Your Ref: OWPC16790
Our Ref: M/123/17/HH 21-11-2017
Please ask for:
Mrs A Gardner

Two storey extension to existing building. Re-submission of M/71/17/HH
Little Thatch 93 Middleton Road Middleton on Sea

Thank you for your internet representation made on 2nd January 2018 which has been recorded as '**an objection**' with the comments as follows:

EAST ELEVATION

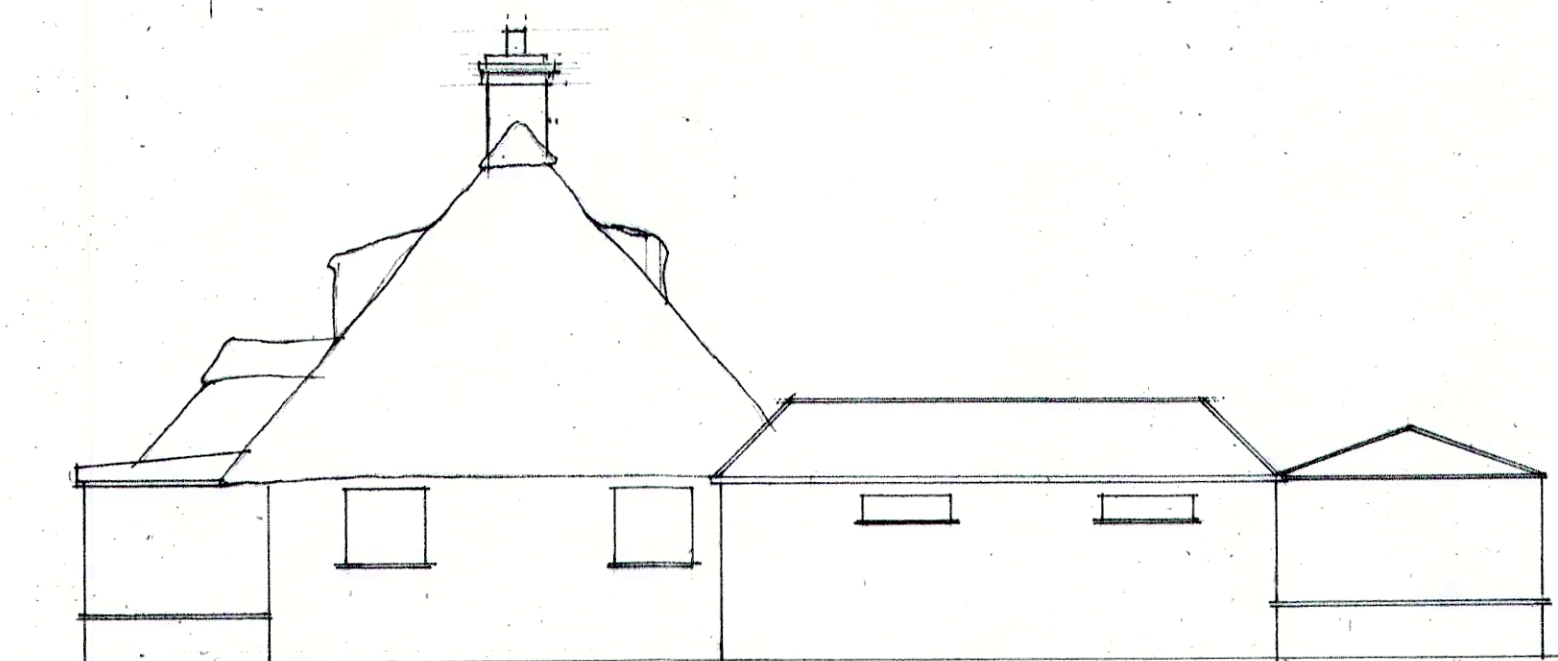
- 1. The bedroom window on the east elevation be replaced with a sky light similar to the one at the other end of the room. This will still let good sunlight into the room but won't then overlook our private seating area.*
- 2. The roof light in the hallway be fitted with the highest level of obscurity and severely limited in size to sustain the privacy into our kitchen diner and private seating area.*
- 3. The new front door to the second dwelling be kept without outside lighting to prevent sensor lighting turning on and off and disturbing the baby whose bedroom overlooks this area and maintaining privacy to our kitchen diner.*
